Your ref:
Our ref: 24/00049/LDP
Please ask for: Valera Lvov
Direct dial: 01553 616865
E-mail: borough.planning@west-norfolk.gov.uk

TOWN AND COUNTRY PLANNING ACT 1990

Details: **At present we have three rooms over our garages, these are currently used mostly for storage. The garages already have fully fireproof ceilings and the rooms have been decorated as typical bedrooms by the previous owner, We would like to move an existing stud partition wall and add an additional wall to install a shower room. There would be no external alterations and no structural alterations. The pipework for drains and water supply would be routed into the rear extension on the ground floor where there is already a toilet & basin. The addition bedrooms and shower room would be used by visitors on an occasional basis. at 63 Chapel Road Dersingham King's Lynn Norfolk PE31 6PJ**

Drawing Number MDH3

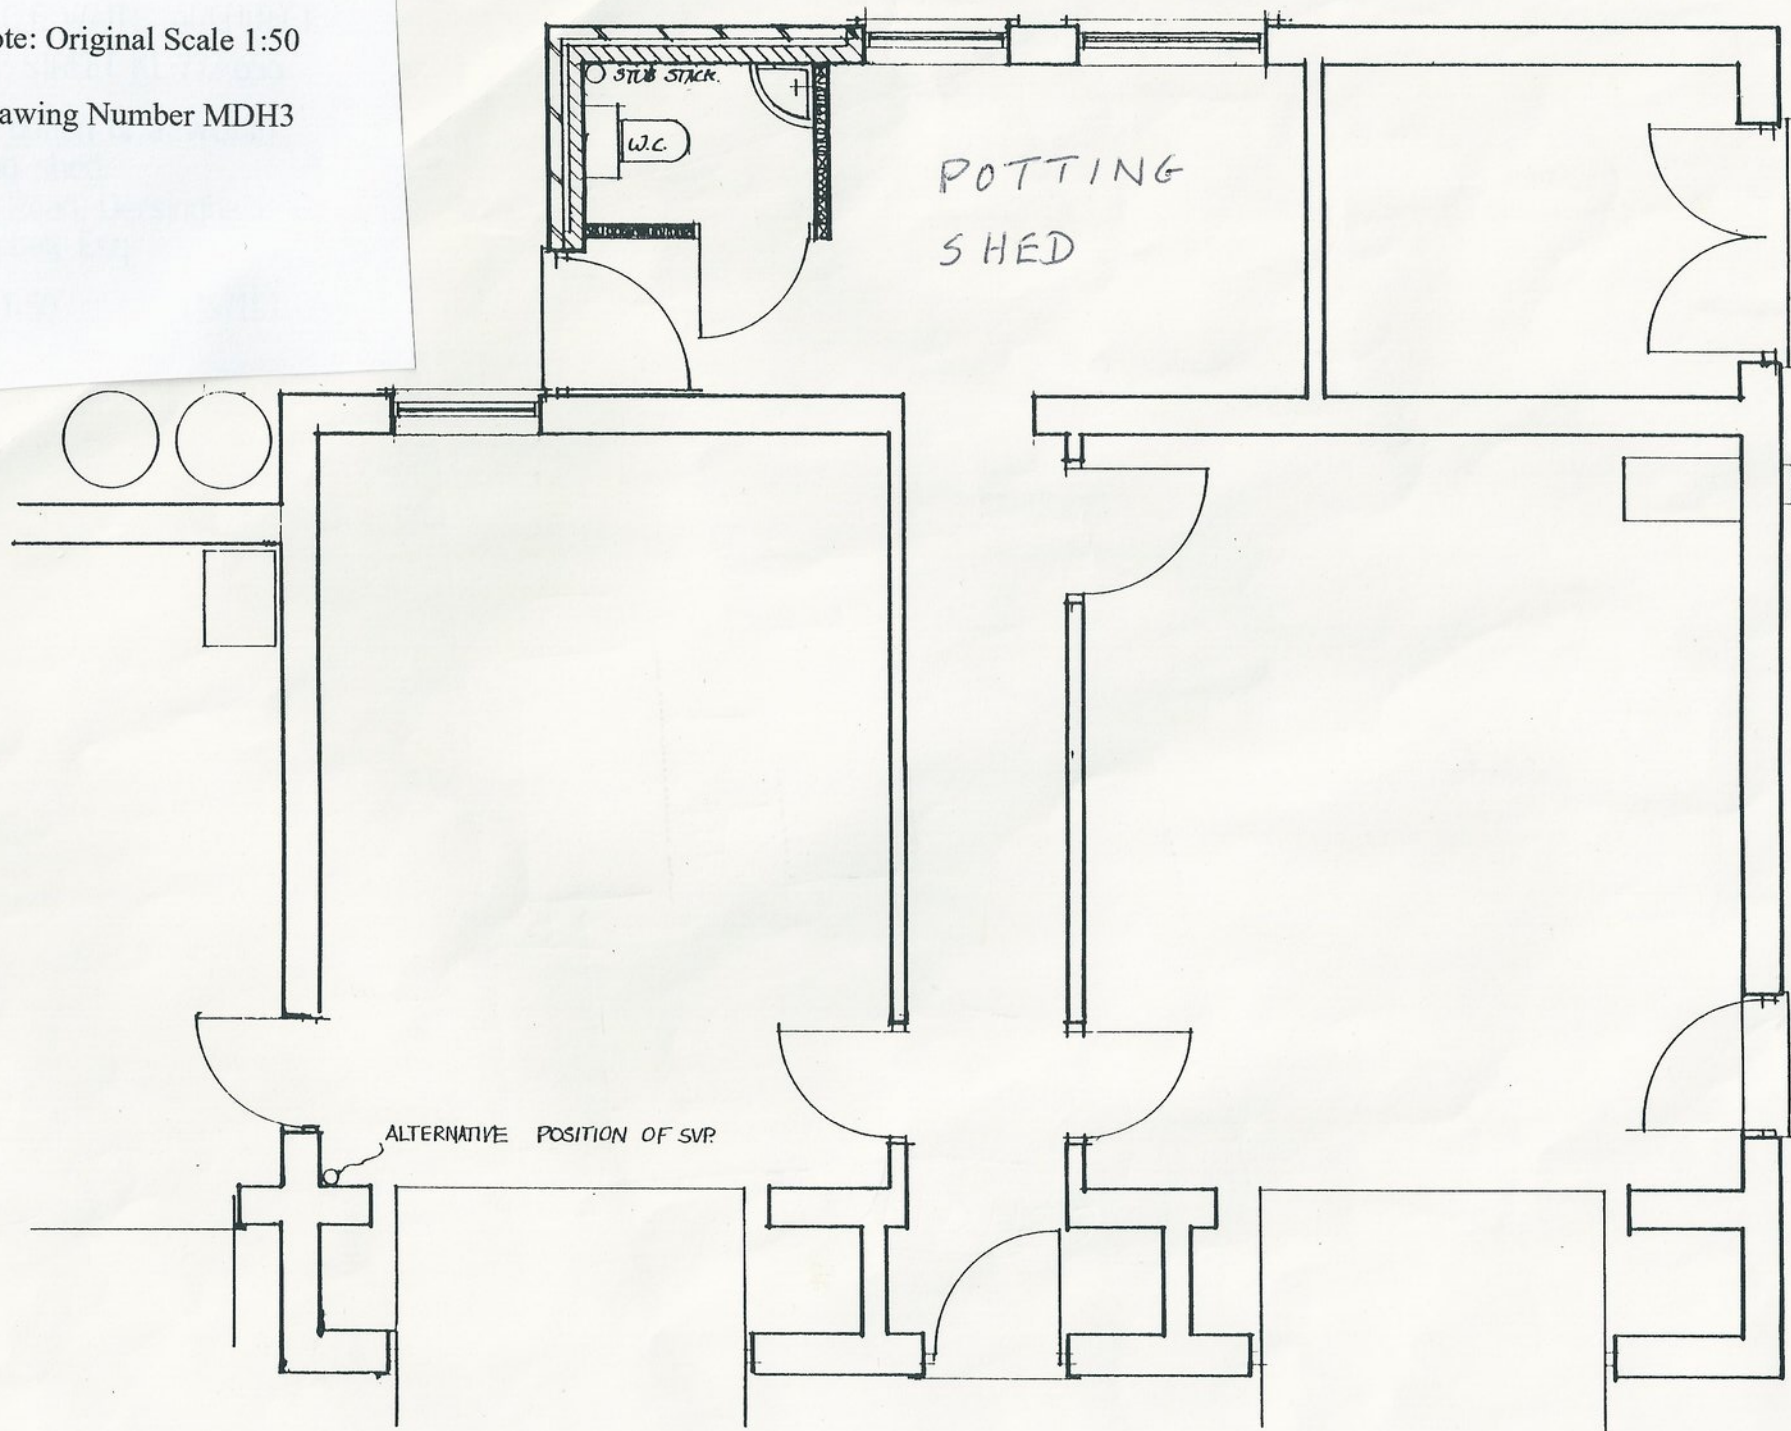
1. A location plan which identifies the land to which the application relates drawn to an identified scale and showing the direction of North. The site should be edged in red and any other adjoining land owned or controlled by the applicant edged in blue. Location plans should be to a scale of either 1:1250 or 1:2500.

The one provided appears to show the dwellinghouse outside of the red line.

FIRST FLOOR PLAN. EXISTING

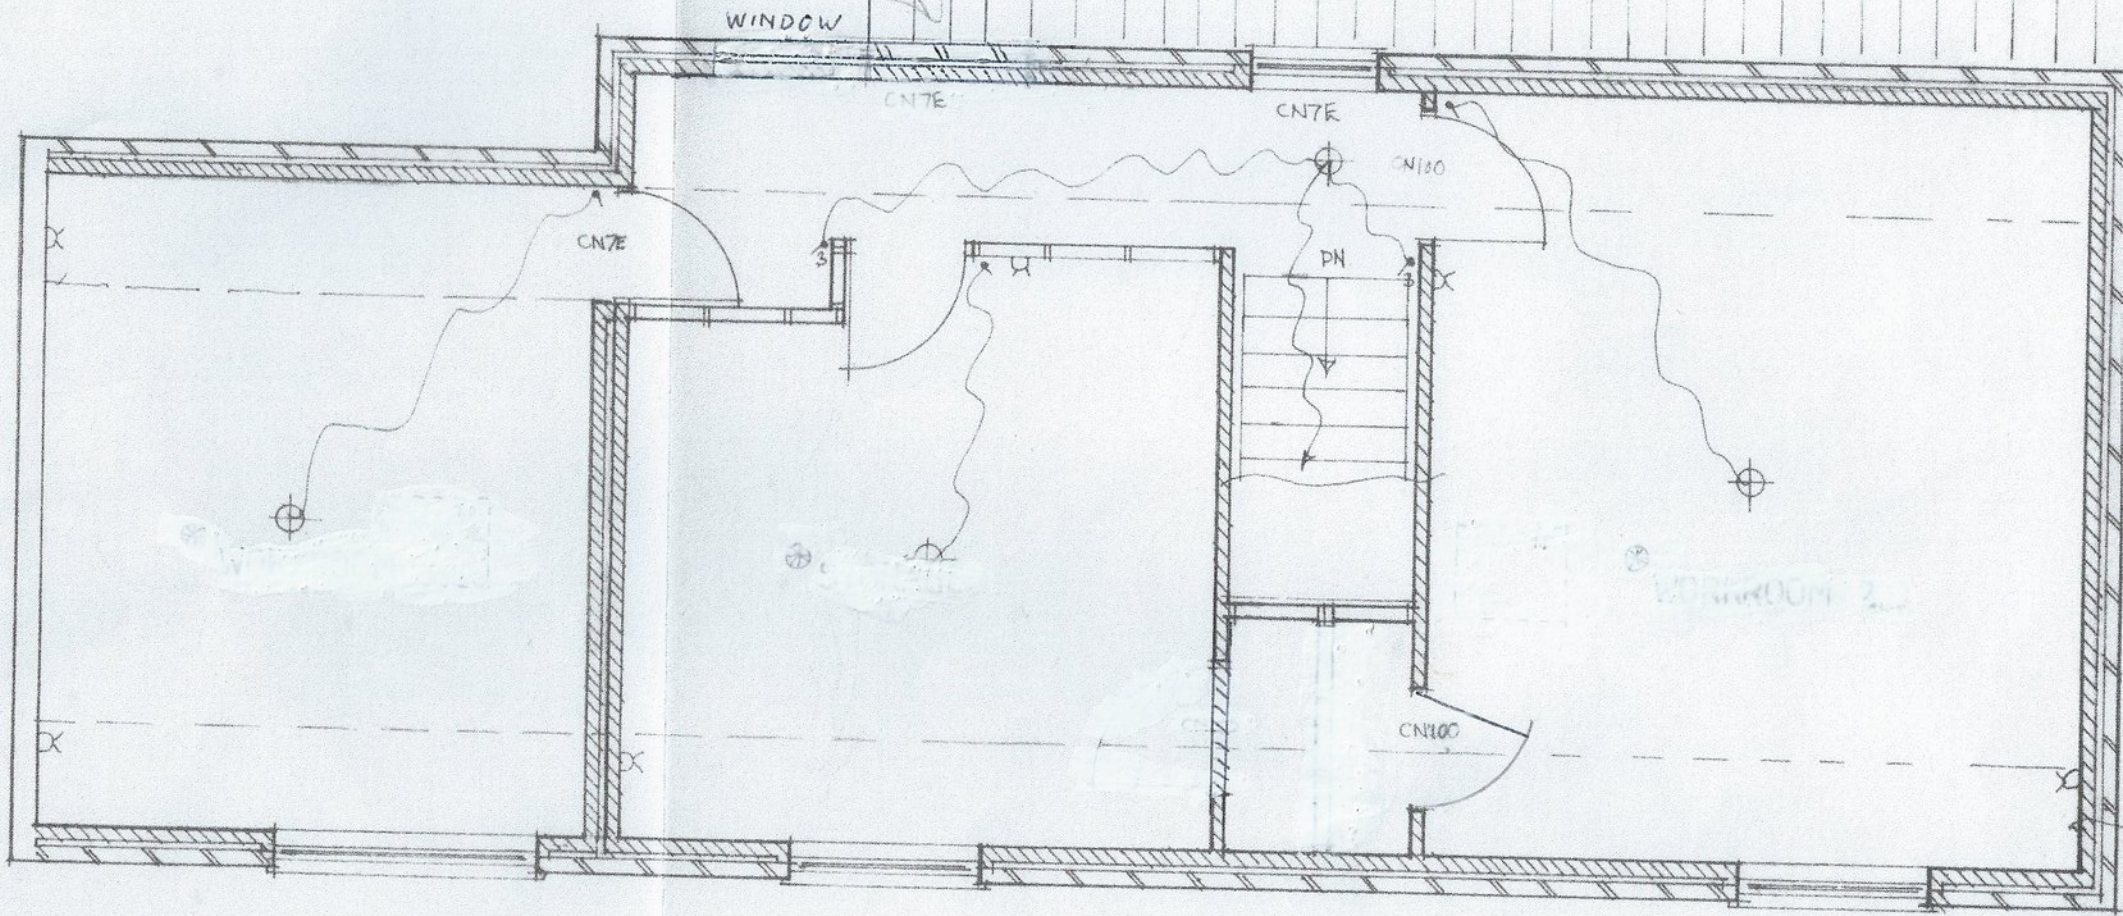
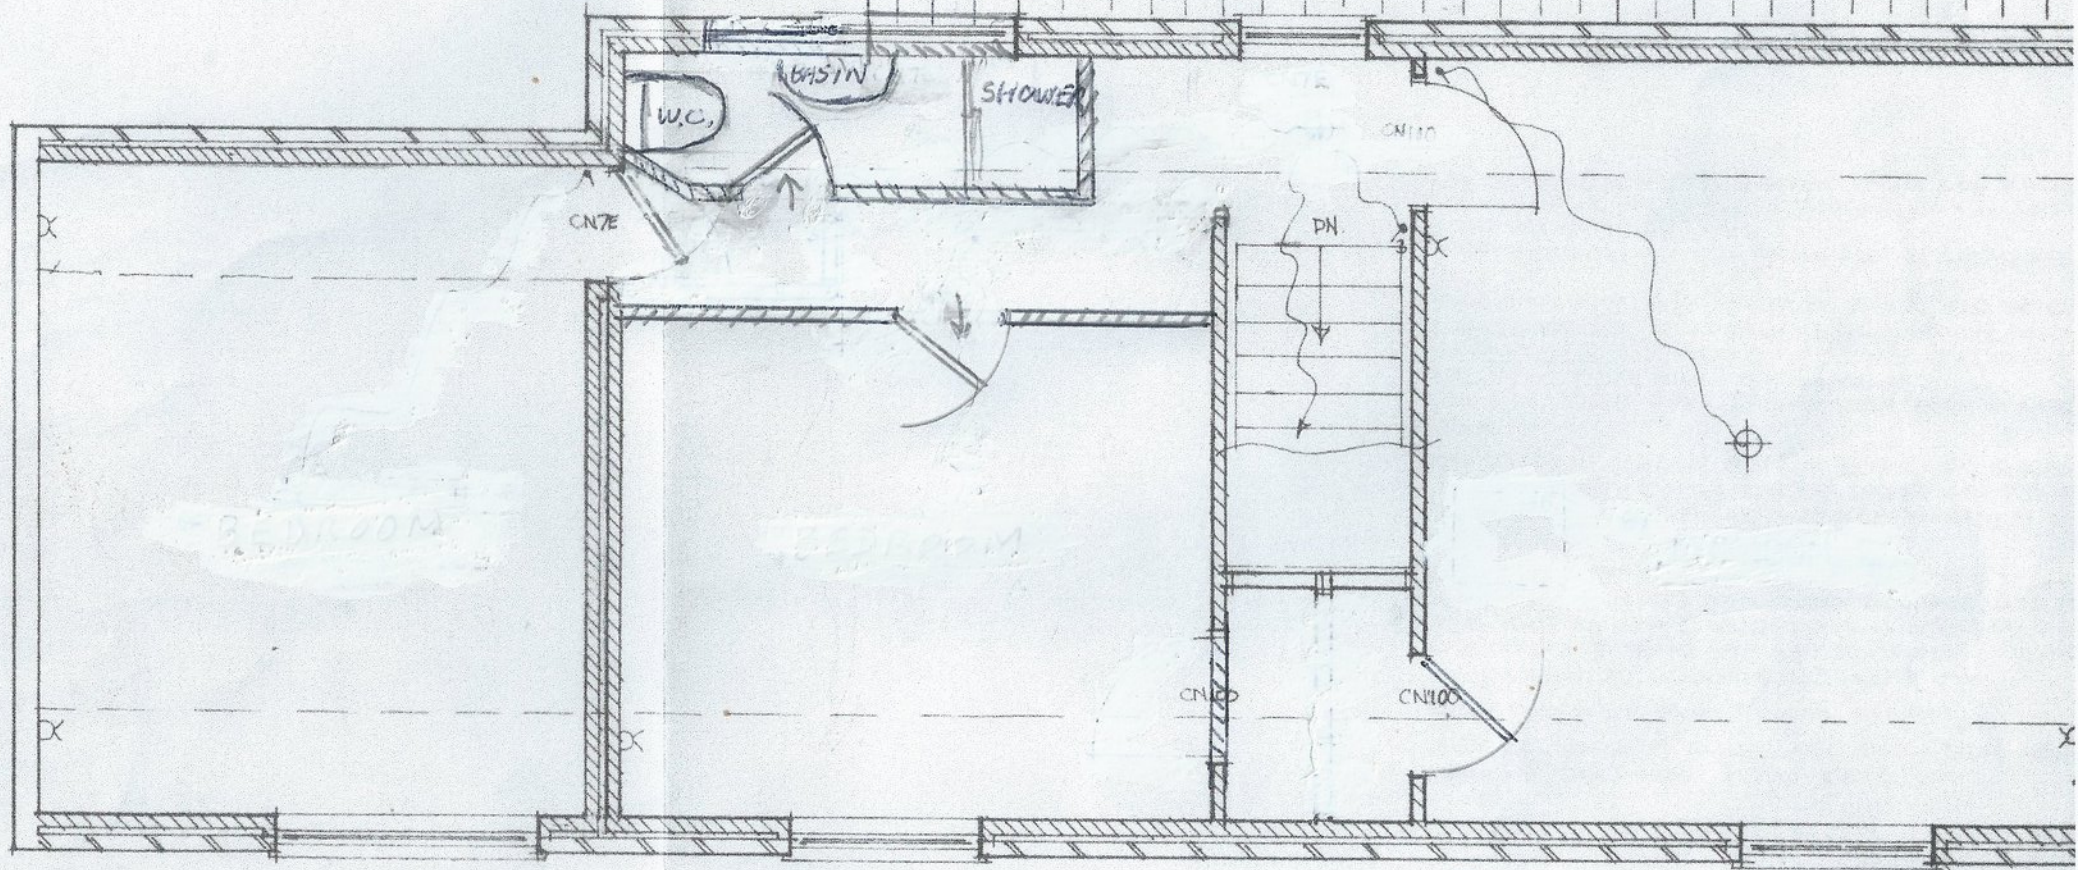
3. Please provide such other information as is considered to be relevant to the application.

- Existing and proposed floor plans to a scale of either 1:50 or 1:100
